CITY OF ALBUQUERQUE

**Re: 5401 Beverly Hills Ave NE
5401 Beverly Hills Ave NE,
30-Day Temporary Certificate of Occupancy
Transportation Development Final Inspection**
Engineer's/Architect's Stamp dated 4-19-18 (B18D023)
Certification dated 4-9-19

A2 SITE PLAN
SCALE: 1" = 20'

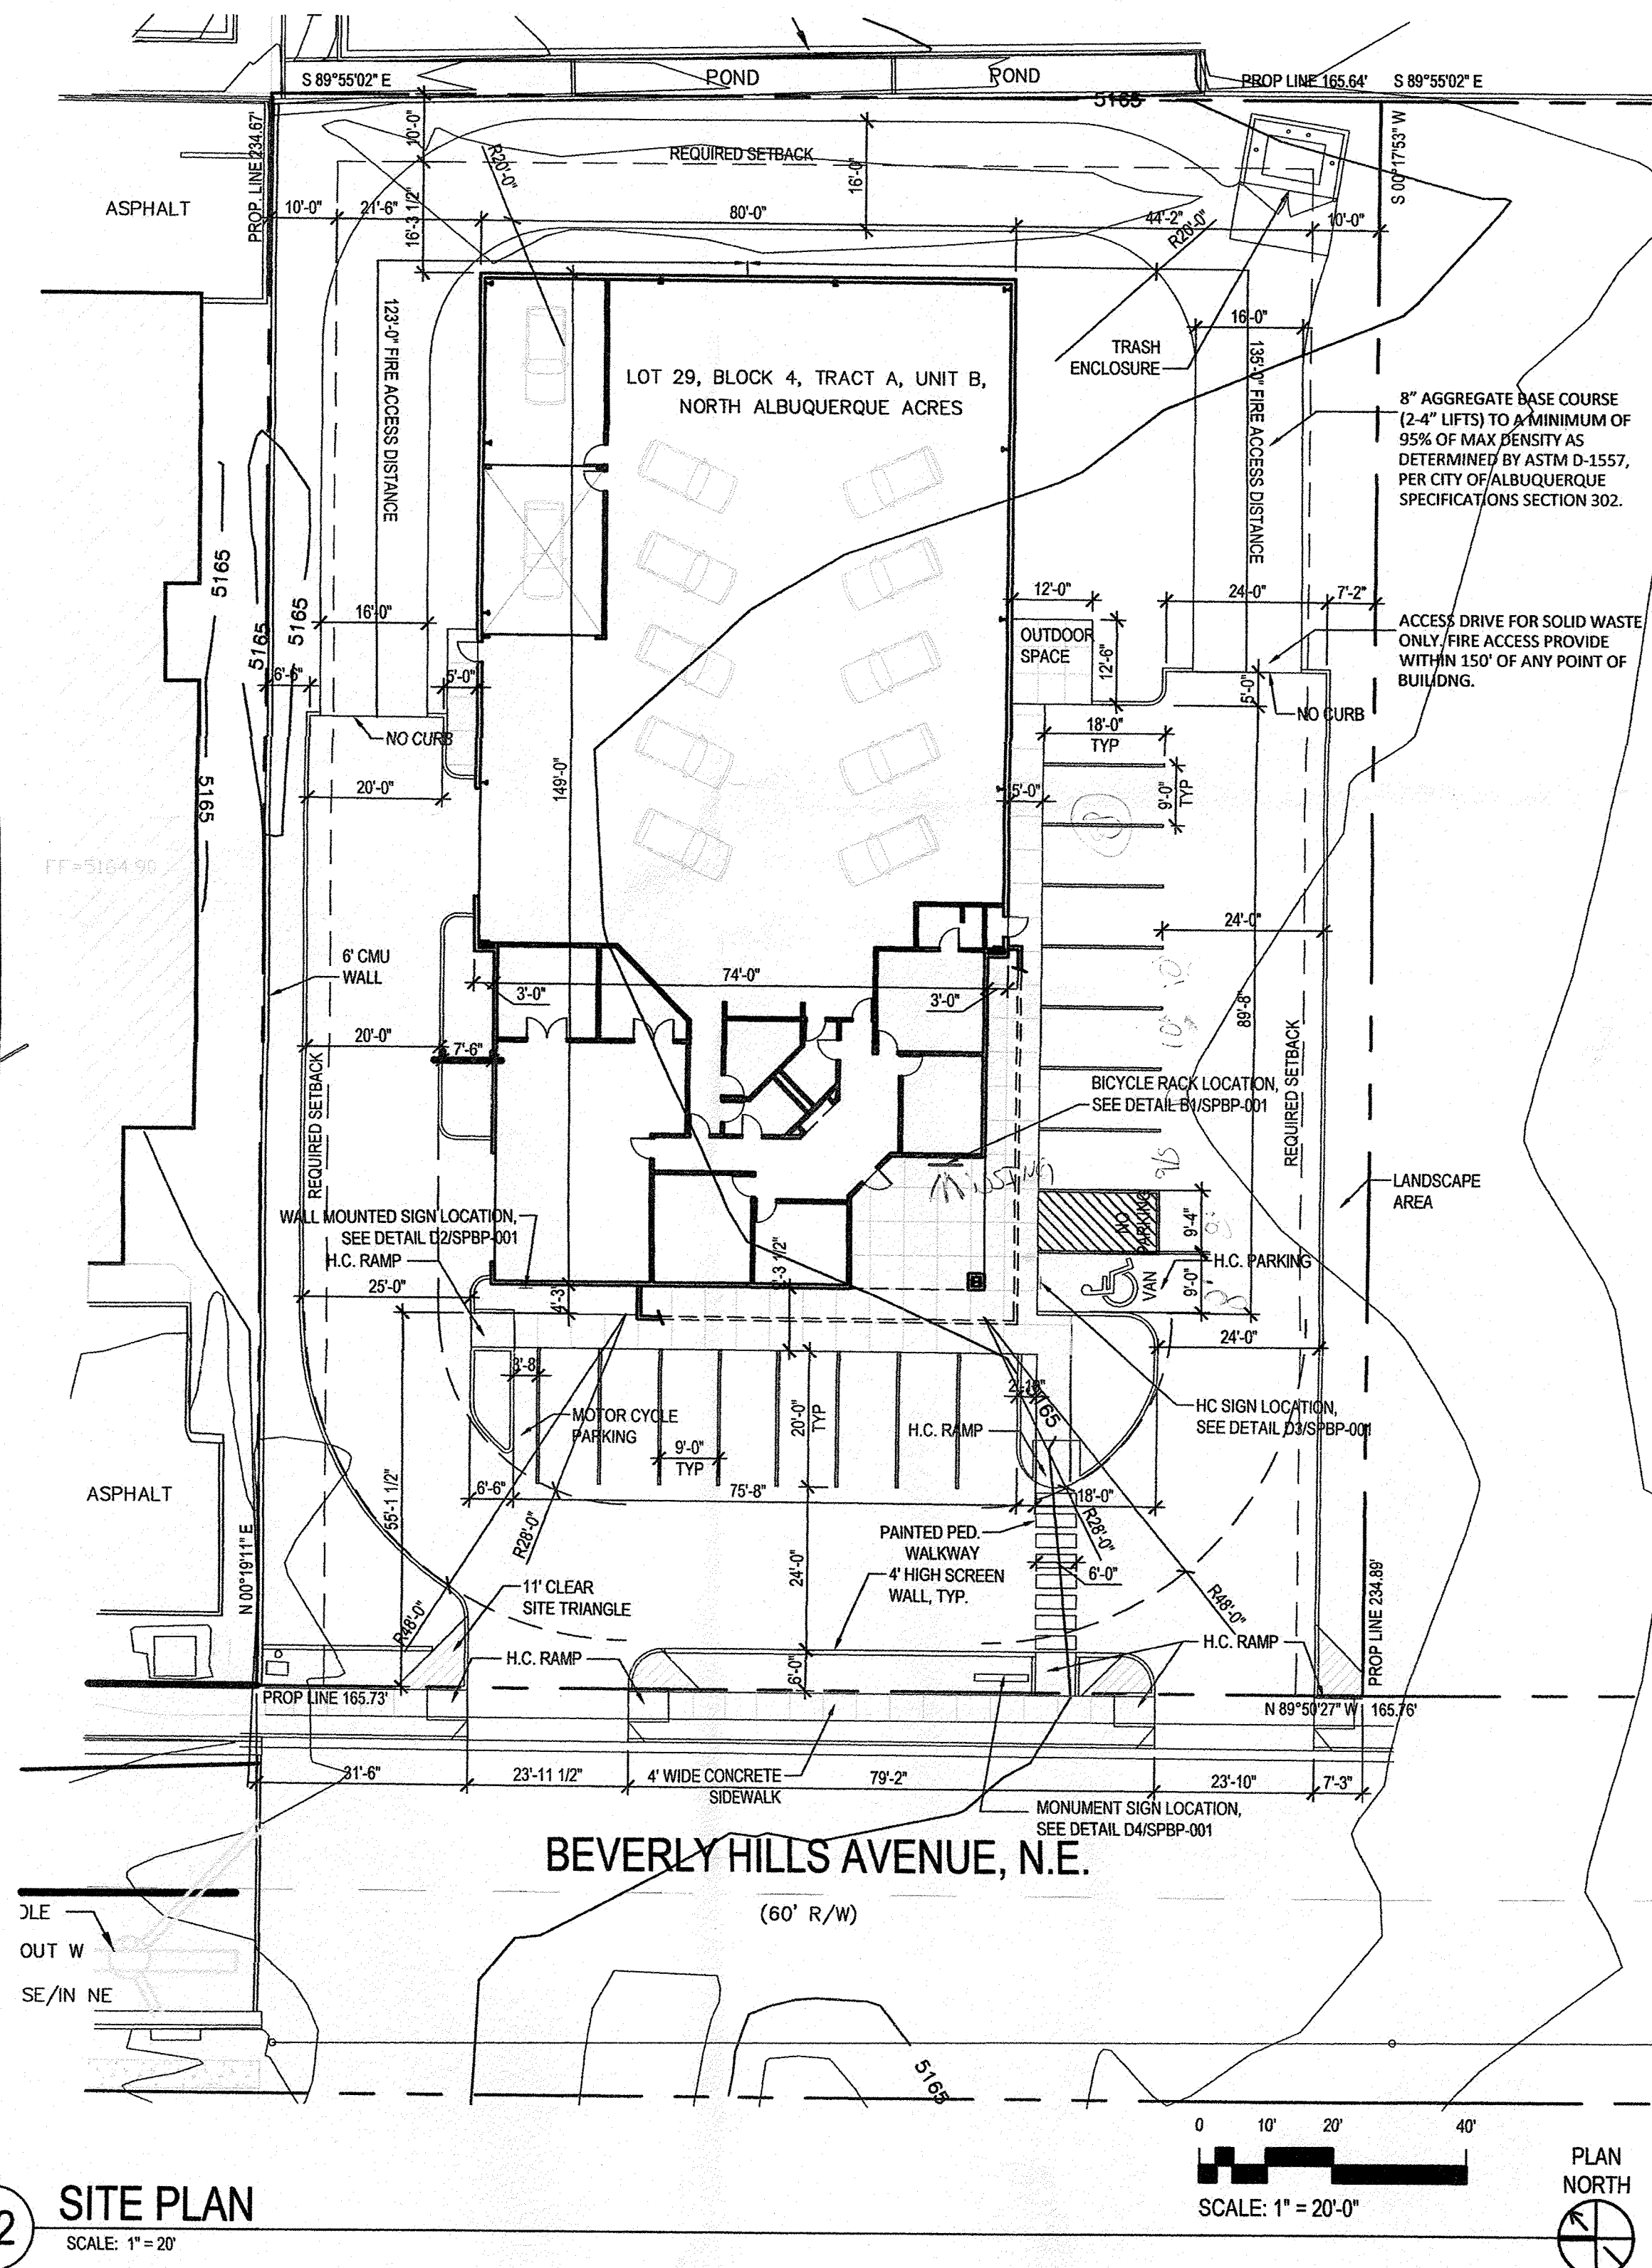
1. Please add bike rack.
2. Please send photos of corrections to PLNDRS@cabq.gov & epgomez@cabq.gov for release of final CO
